WESTMEAD CATHOLIC COMMUNITY EDUCATION CAMPUS APPENDIX A - RESPONSE TO SUBMISSIONS AND REQUEST FOR ADDITIONAL INFORMATION AND CLARIFICATIONS

1 **LEVEL 04**
1 : 200

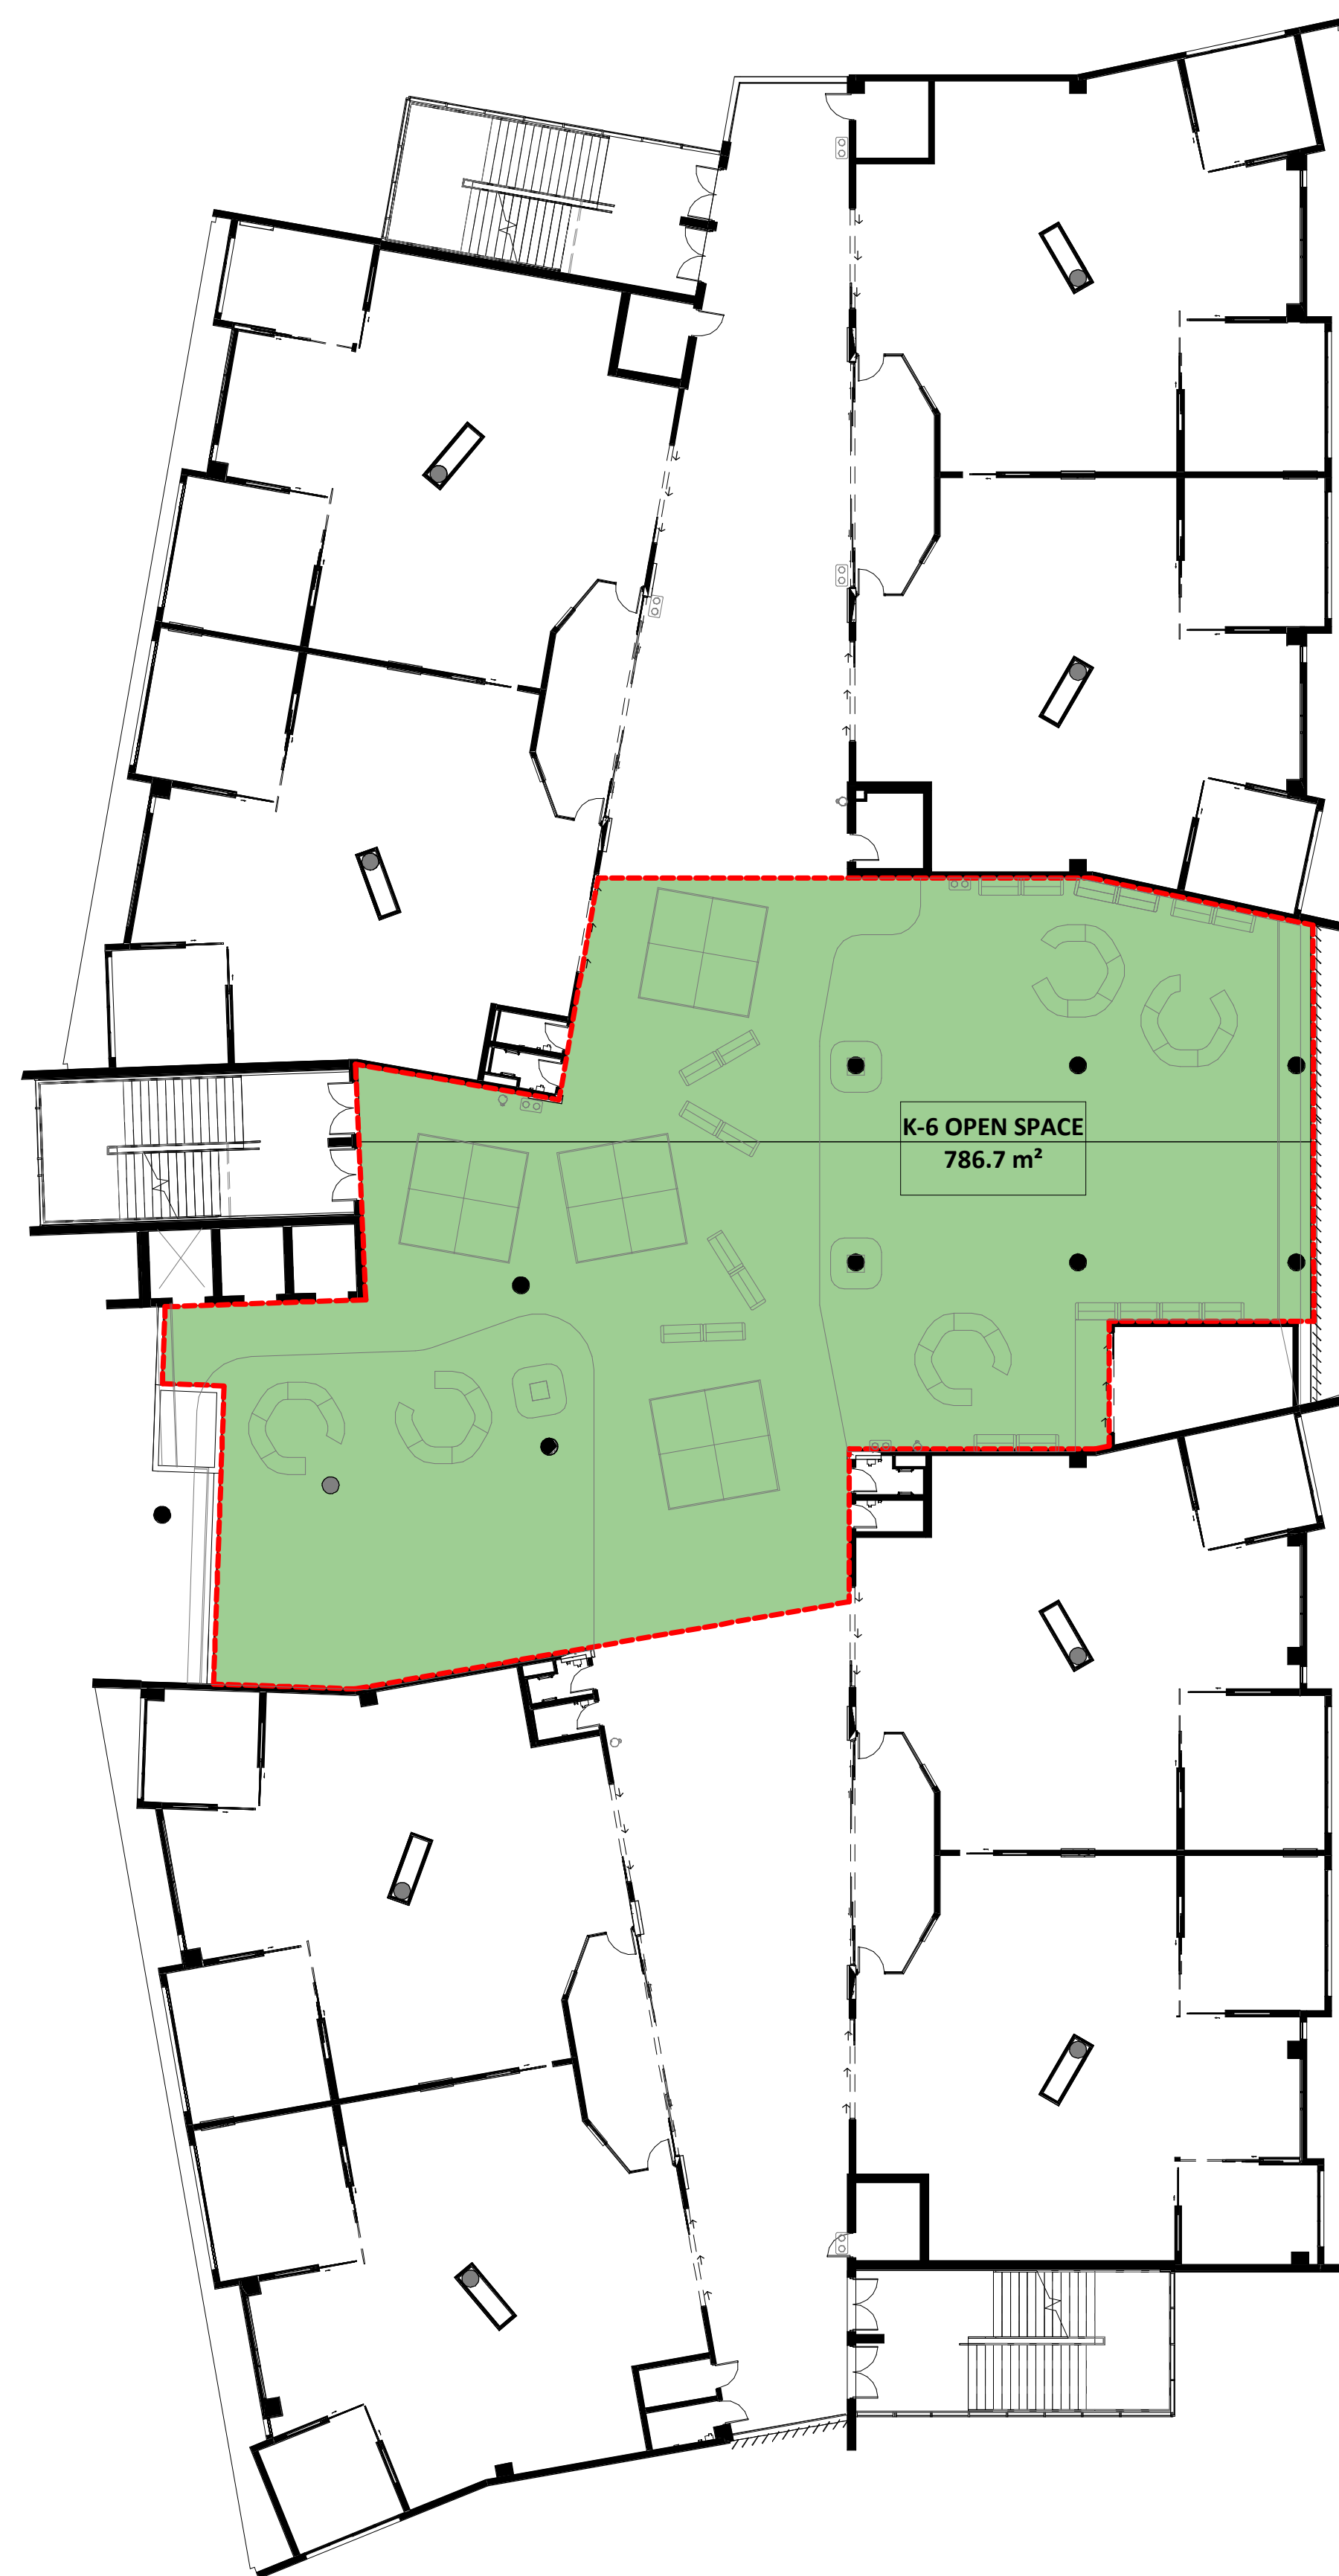
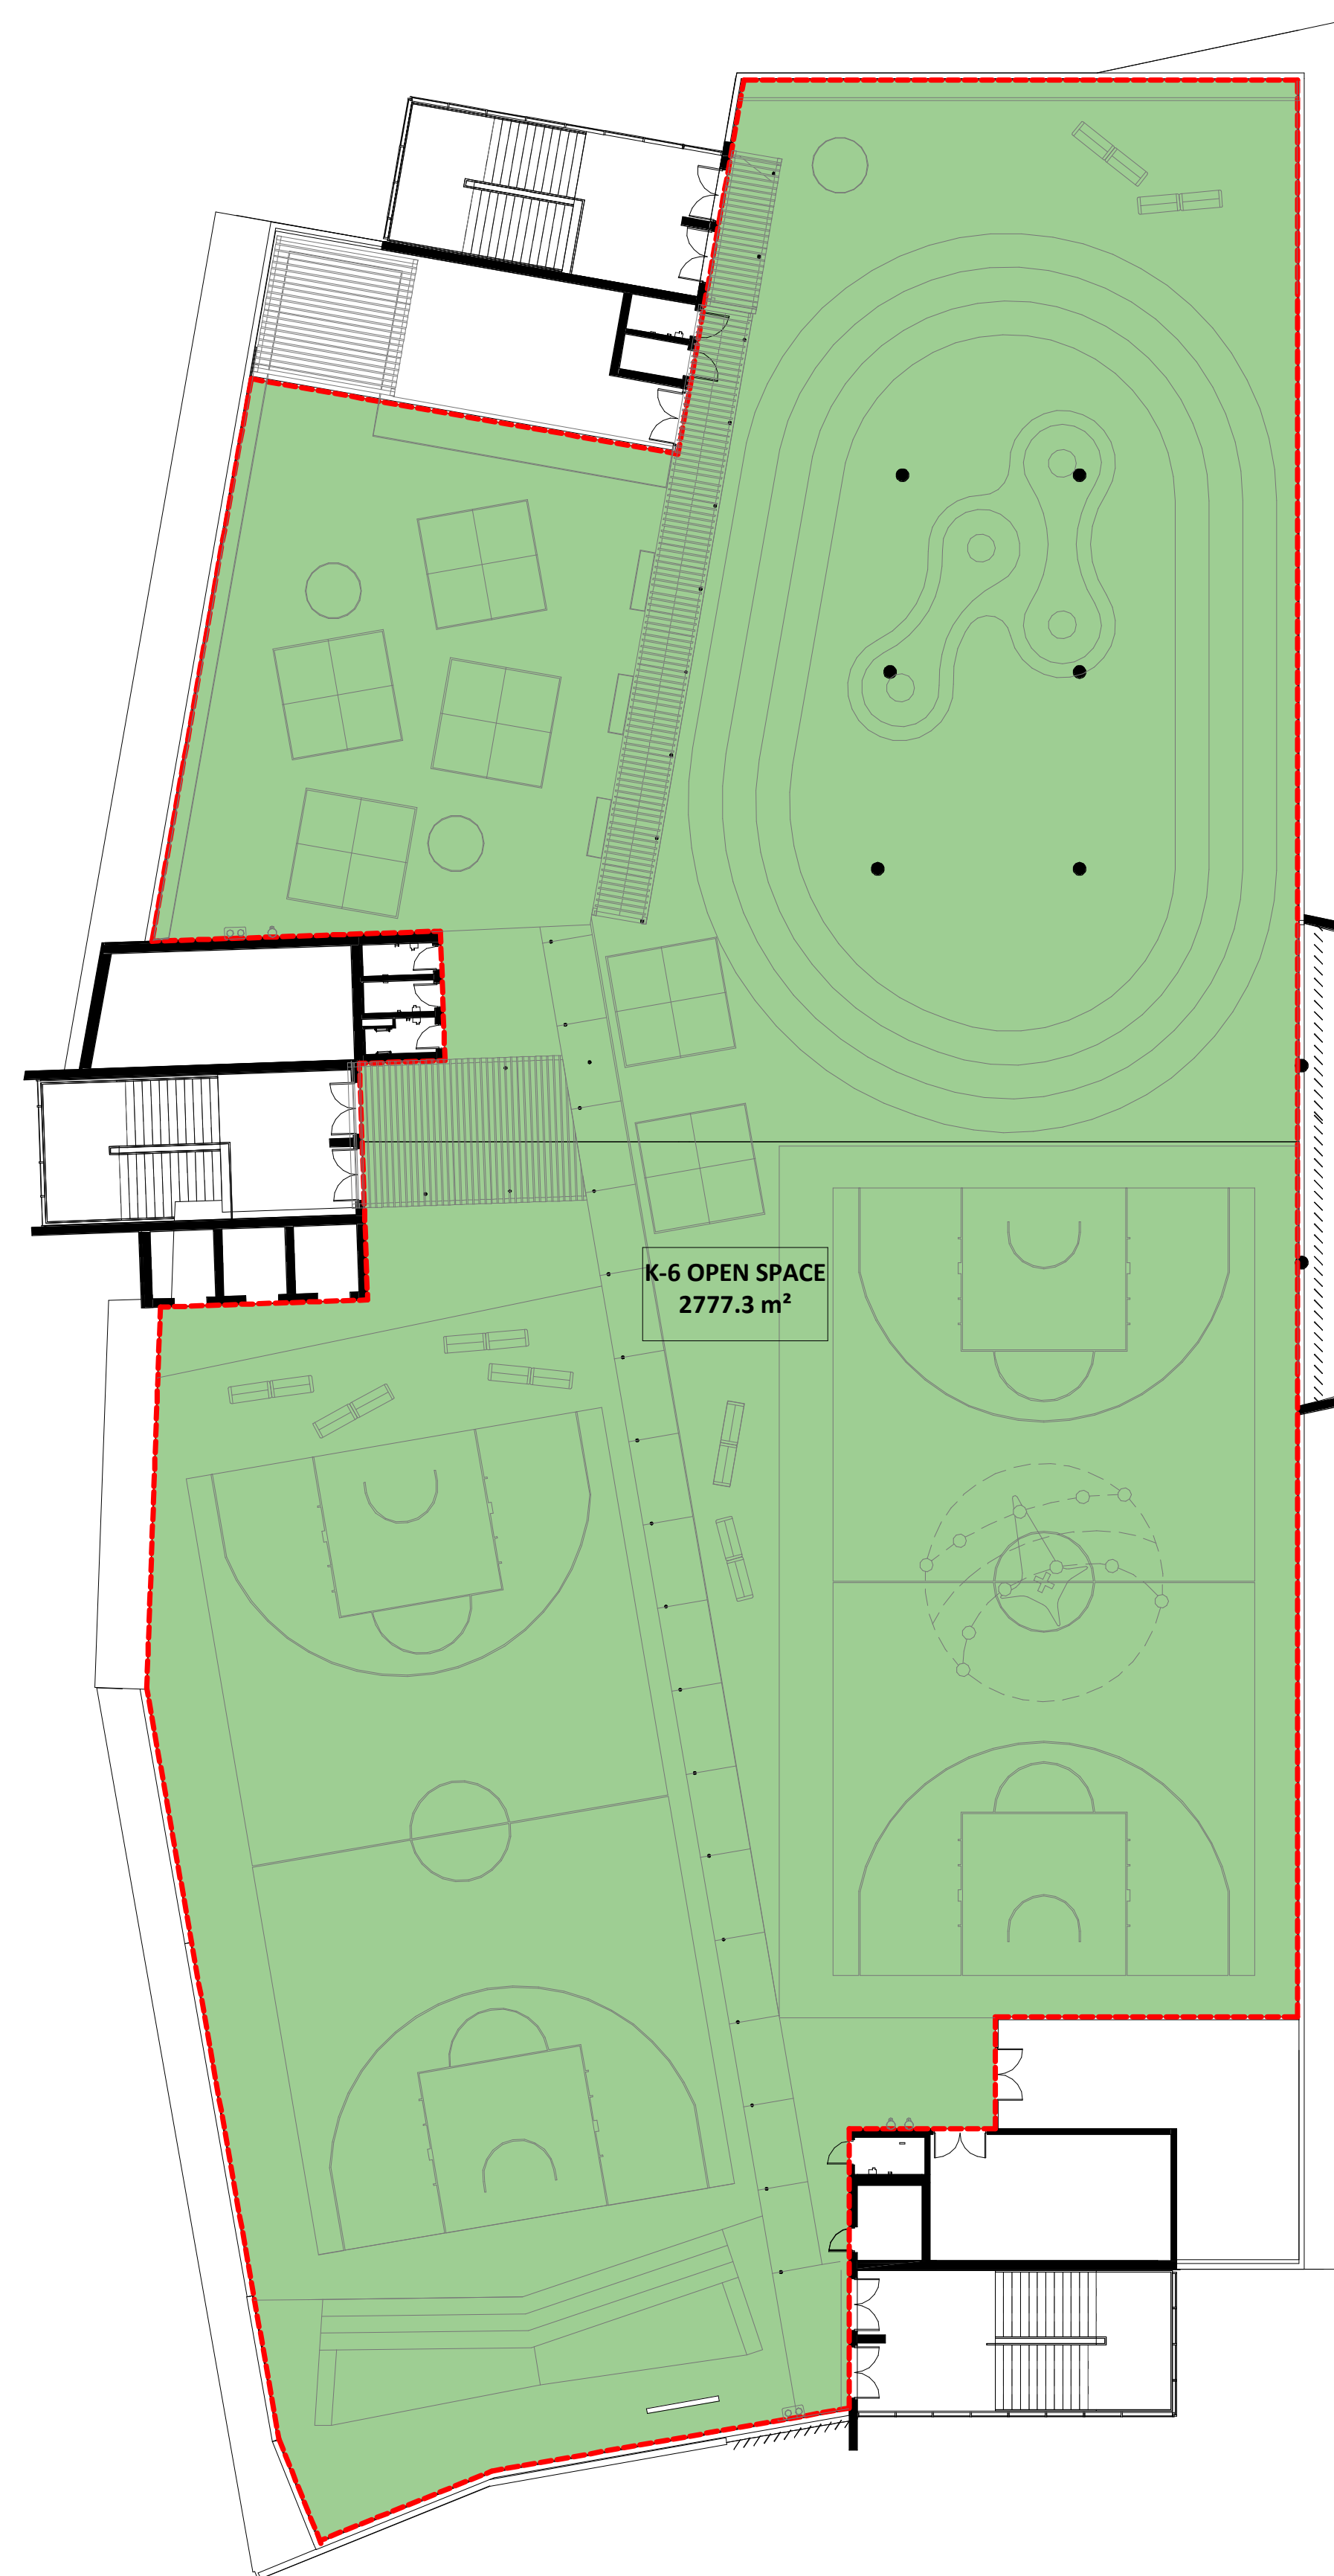
Item No	Name	Type	Issue	Response																		
4			<p>The proposal does not provide the details of the area of open space provided within the building. While there are no minimum requirements for the area of open space per student, Department of Education provides guidance / standards for the minimum area of open spaces required per student within a school. Department of Education's should be used as a guide to demonstrate that suitable open space areas have been provided per student within the site.</p>	<p>Based on these findings, the proposal is considered suitable from a daylight and solar access perspective.</p> <p>A detailed response to the Department's open space comments is provided in the covering Response to Submissions Report.</p> <p>The revised Architectural Drawings (Appendix B) quantify the open space within the building. The diagrams show that there will be over 7,800m² of open space across Levels 1 – 5 (i.e. all ground level play space, including the ground level undercroft, is in addition to this). This equates to 4.6m² per student, within the building. The plans outline that the open space has been specifically located so that the relevant open space for each age group is within one floor of the learning areas. This ensures that each year group will have direct access during mid-morning and lunch breaks, with no wasted time travelling to access these open spaces.</p> <p>On ground level, there is an additional 6,070m² of open space. This includes the undercroft and outdoor area adjacent to the new Primary School Building, but excludes the ovals. This additional area equates to 3.6m² of additional open space per student, taking the total open space provision to 8.2m² per student. A summary of these figures is provided below.</p>

<table><tr> <th colspan="2">OPEN SPACE CALCULATIONS</th> </tr><tr> <td>Ground Floor</td> <td>6070.8 m²</td> </tr><tr> <td>Level 01</td> <td>742.6 m²</td> </tr><tr> <td>Level 02</td> <td>755.2 m²</td> </tr><tr> <td>Level 03</td> <td>2804.8 m²</td> </tr><tr> <td>Level 04</td> <td>786.7 m²</td> </tr><tr> <td>Level 05</td> <td>2777.3 m²</td> </tr><tr> <td></td> <td>13937.4 m²</td> </tr></table>

<p>Open Space Ratio 8.23 m²/student</p> <p>For clarity, the primary children will access the ovals for delivery of the PDHPE curriculum but they are not included in the play space calculation. More broadly, at the completion of the Master Plan, there will be more play space area per student than recommended by the EFSG. Preliminary figures indicate that the total area per student will be approximately 20% greater than the EFSG at the completion of Project 1, Stage 2 (refer to details of Master Plan below).</p>	OPEN SPACE CALCULATIONS		Ground Floor	6070.8 m ²	Level 01	742.6 m ²	Level 02	755.2 m ²	Level 03	2804.8 m ²	Level 04	786.7 m ²	Level 05	2777.3 m ²	Not Placed	Not Placed		13937.4 m ²
OPEN SPACE CALCULATIONS																						
Ground Floor	6070.8 m ²																					
Level 01	742.6 m ²																					
Level 02	755.2 m ²																					
Level 03	2804.8 m ²																					
Level 04	786.7 m ²																					
Level 05	2777.3 m ²																					
Not Placed	Not Placed																					
	13937.4 m ²																					
5			<p>The open space diagrams indicate that circulation areas in between classrooms have been added as open spaces. The circulation areas should be deleted from the calculation of open space areas.</p>	<p>All spaces are used as multi-purpose spaces – circulation spaces will be used for access, play and learning. It is also noted that peak play times and circulation times are different, and so it is appropriate for circulation areas to be considered as part of the open space calculation.</p>
